Your ref:
Our ref: 24/00056/F
Please ask for: Valera Lvov
Direct dial: 01553 616865
E-mail: borough.planning@west-norfolk.gov.uk

TOWN AND COUNTRY PLANNING ACT 1990

Details: **Insertion of 3 Velux Conservation Roof Windows to north roof slope of single storey rear projection; combination of two external openings to south wall of single storey rear projection and formation of single larger opening with powder coated aluminum sliding doors; replacement of existing access door to rear gable wall of single storey rear wing with glazed timber window; mounting of solar PV panels on south roof slope to single storey rear wing. at The Porch House Hall Lane Thornham Hunstanton Norfolk**

File No: 2023/18 Drawing No: 2/B

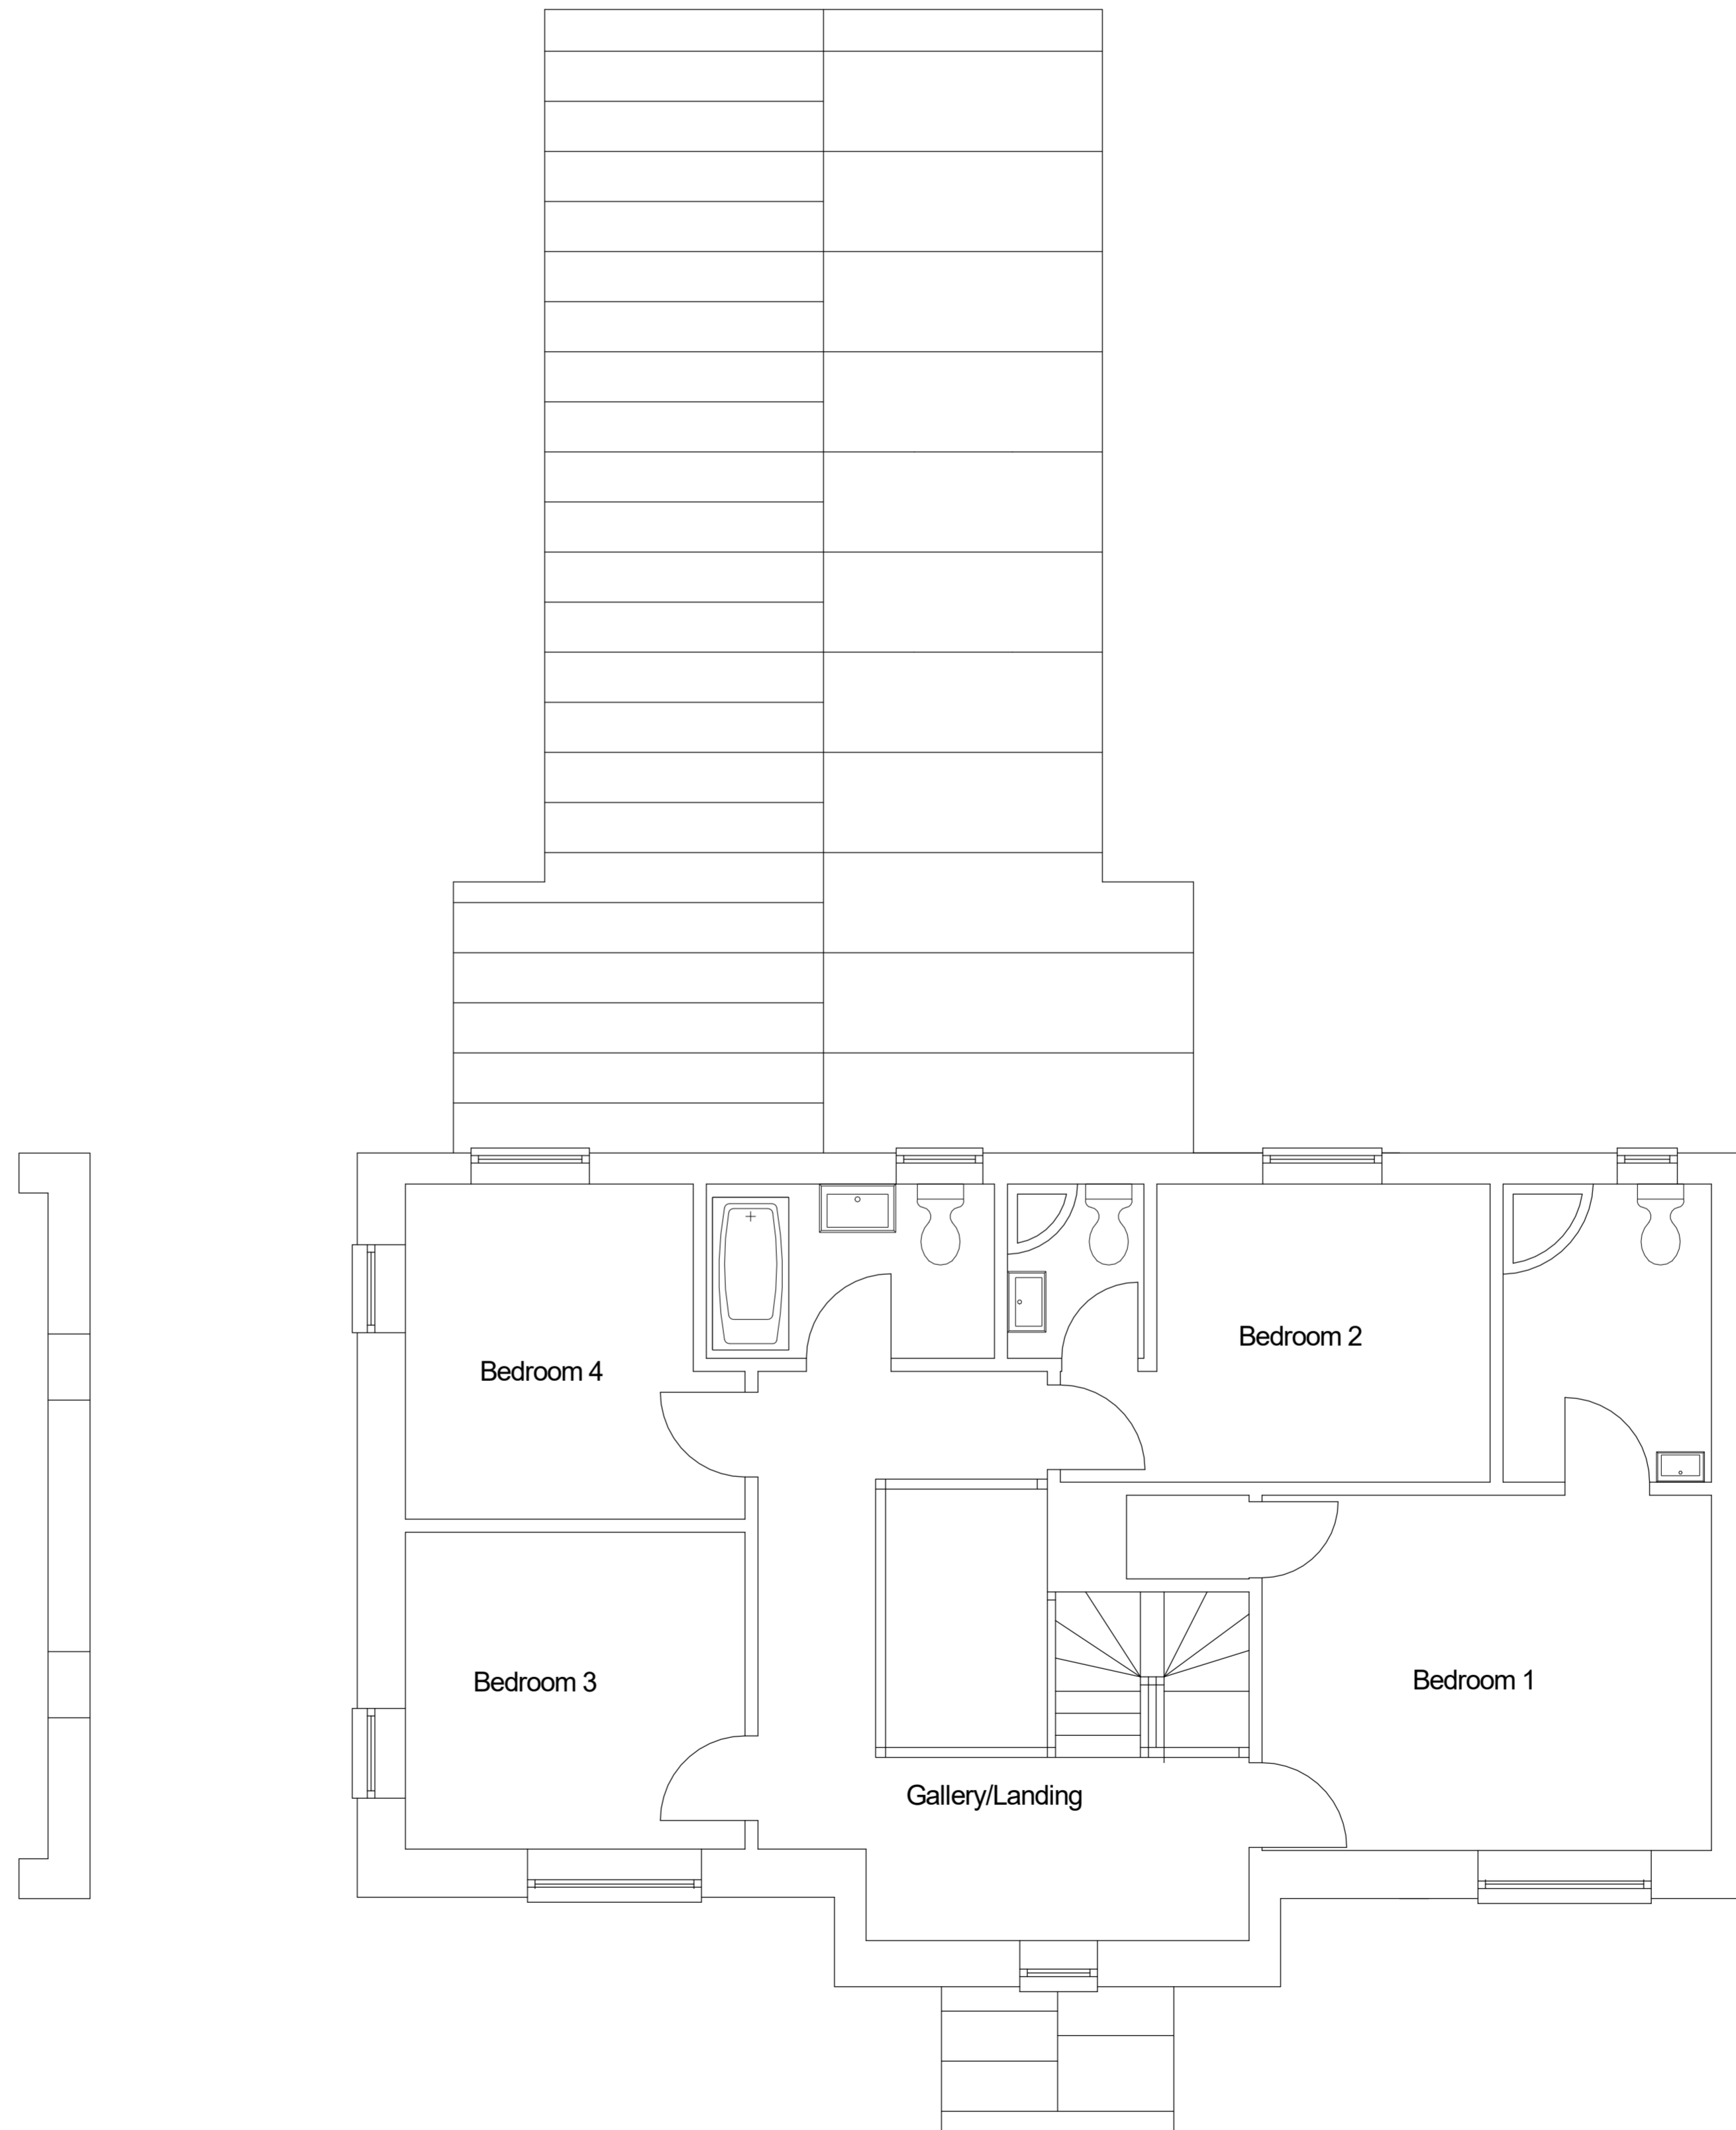
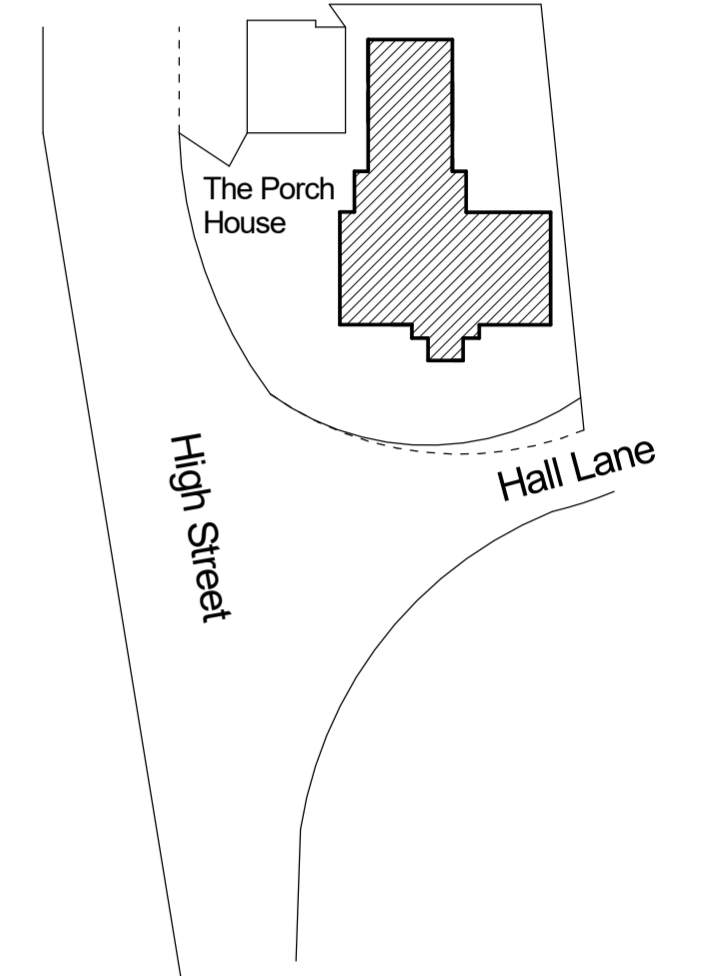
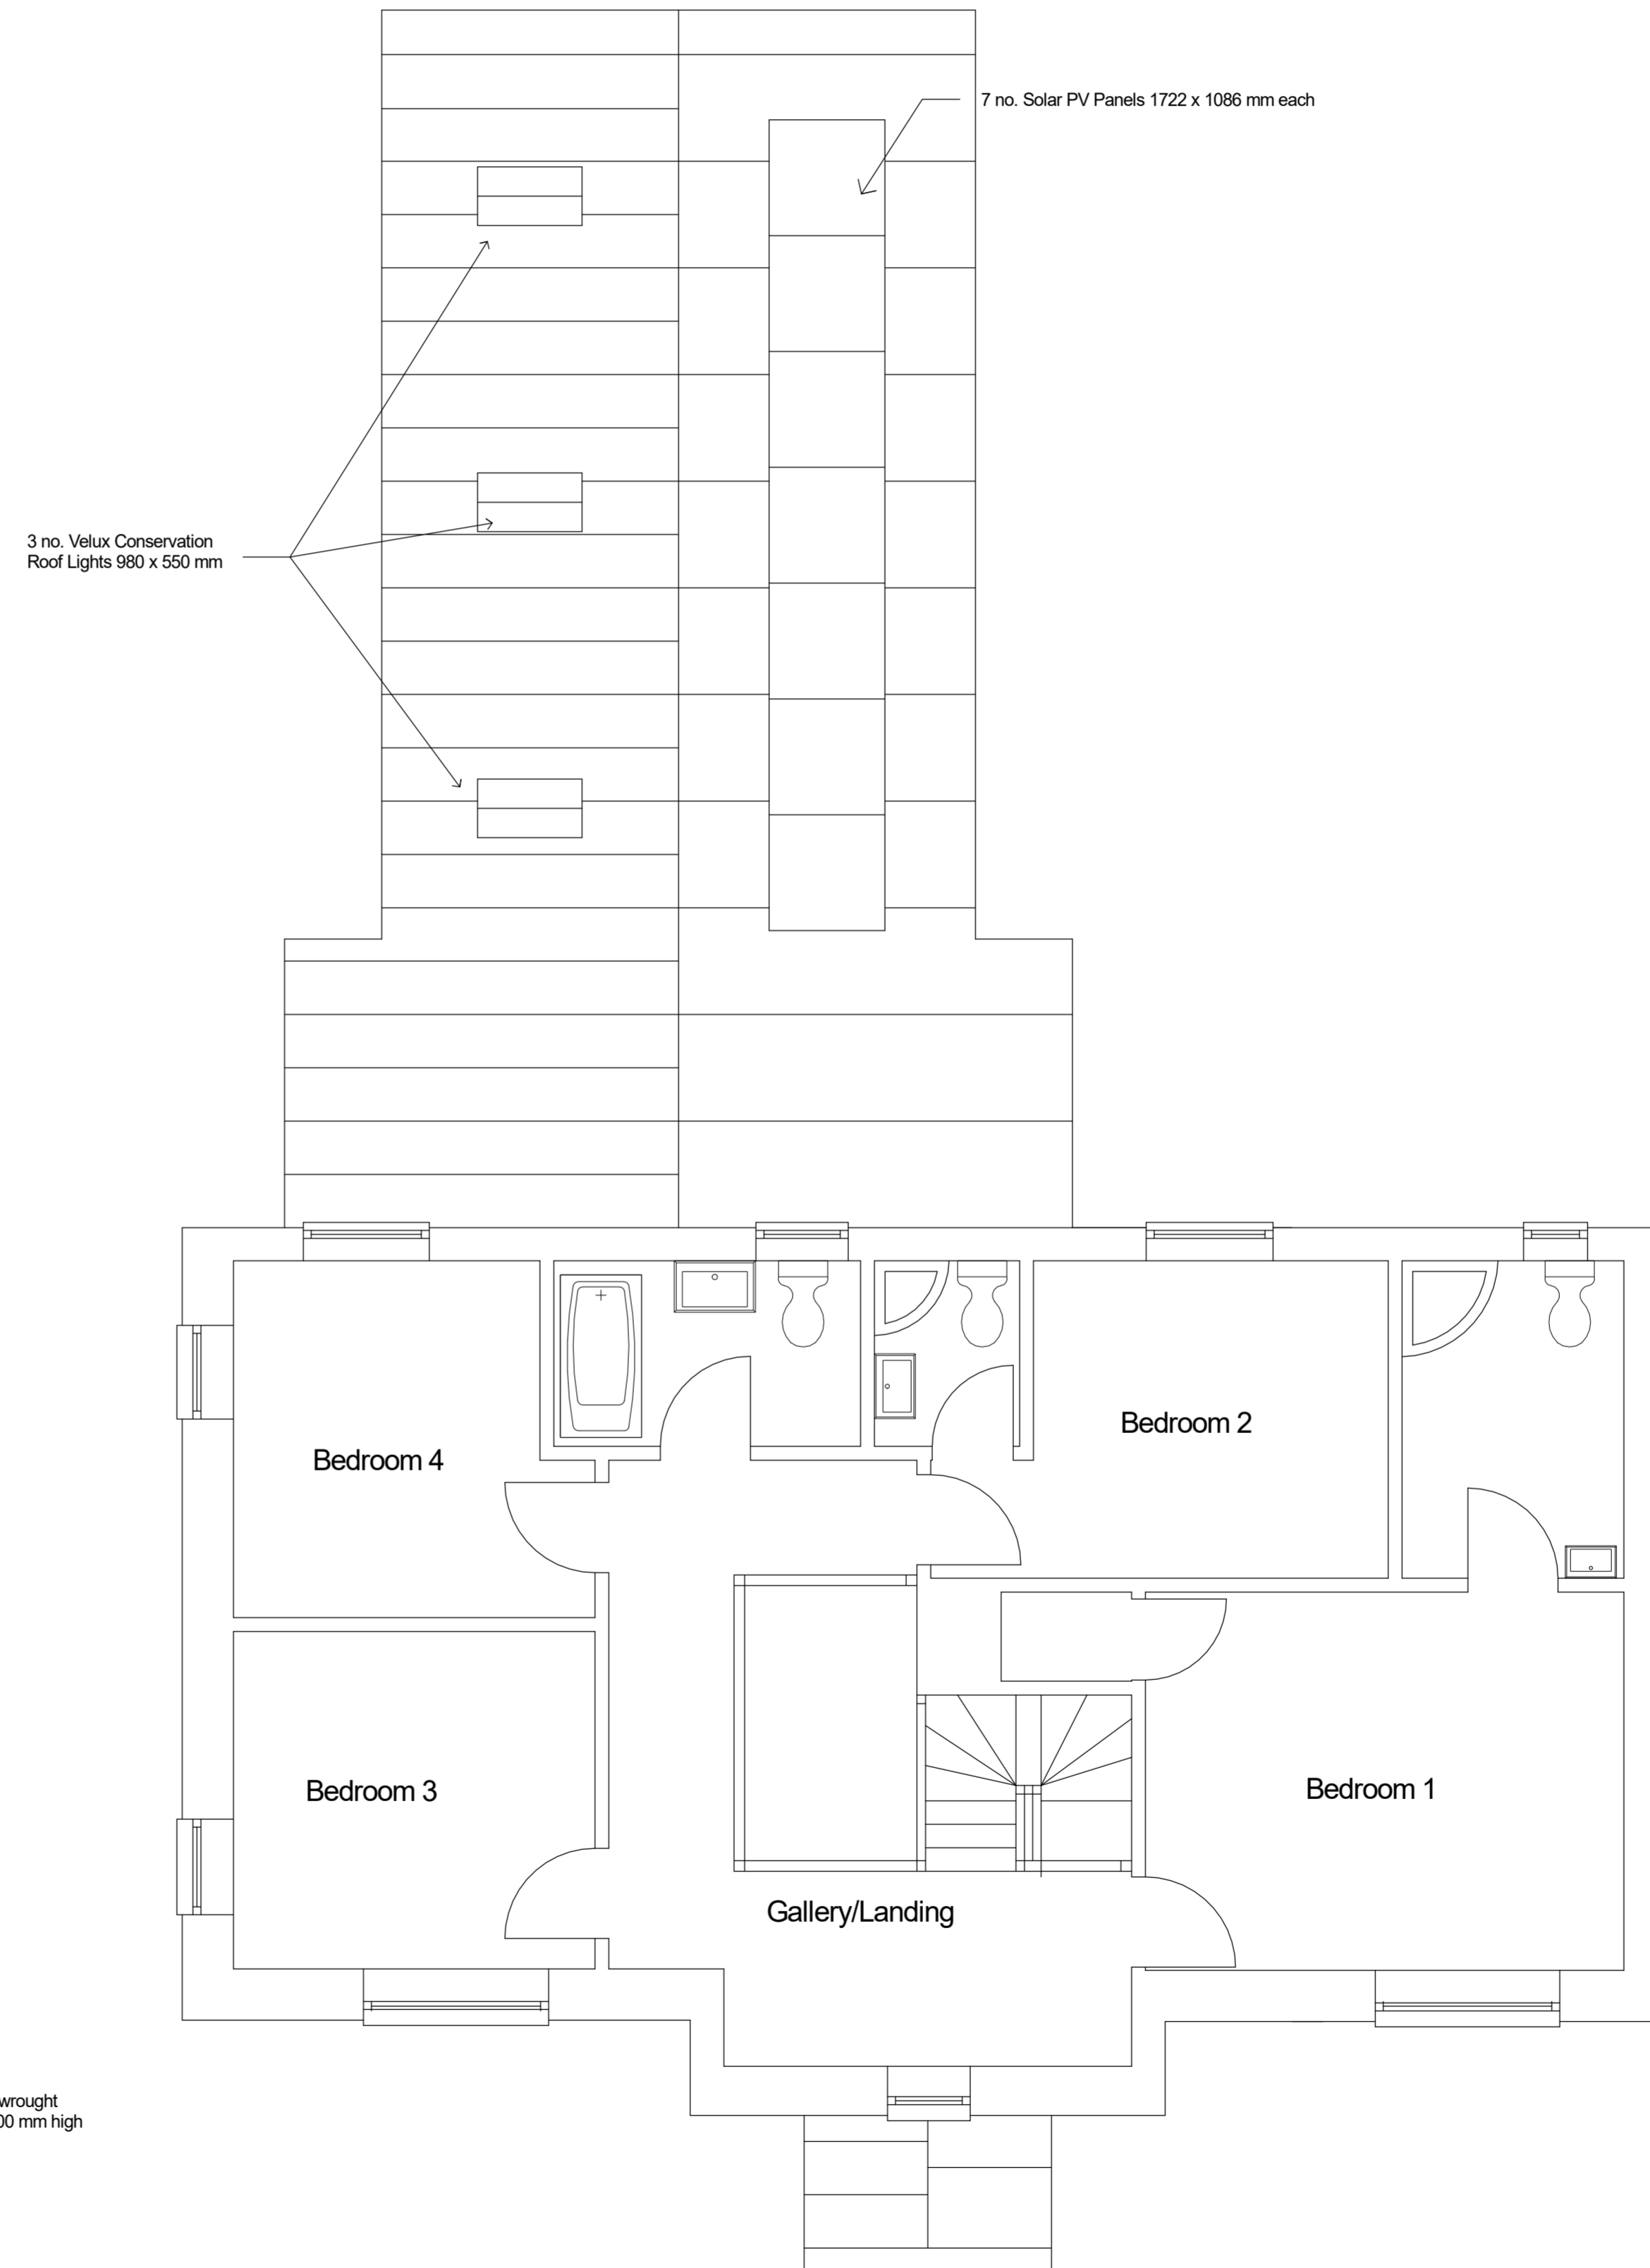
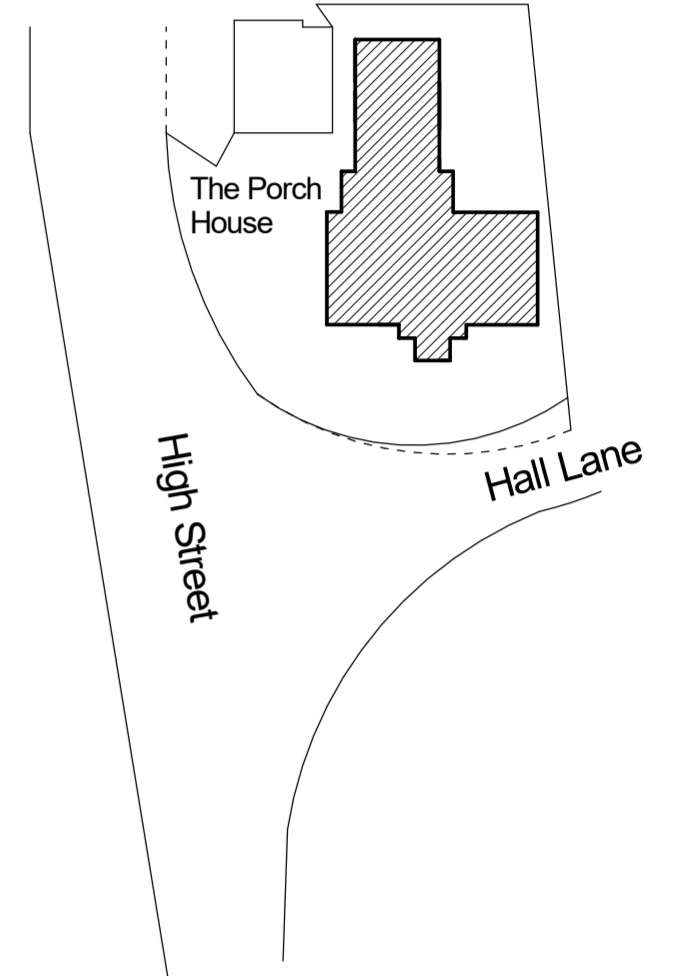
1. Please amend the drawings. Drawings annotated "Not to Scale" or "Do Not Scale" or similar wording will result in the application being invalidated. All drawings must be drawn true to the stated scale(s).
2. Please provide a Roof plans to a scale of either 1:50 or 1:100
3. Can you confirm if you are happy to shorten the proposal description to the following;
"Alterations and repairs to the existing building and installation of Solar PV panels."
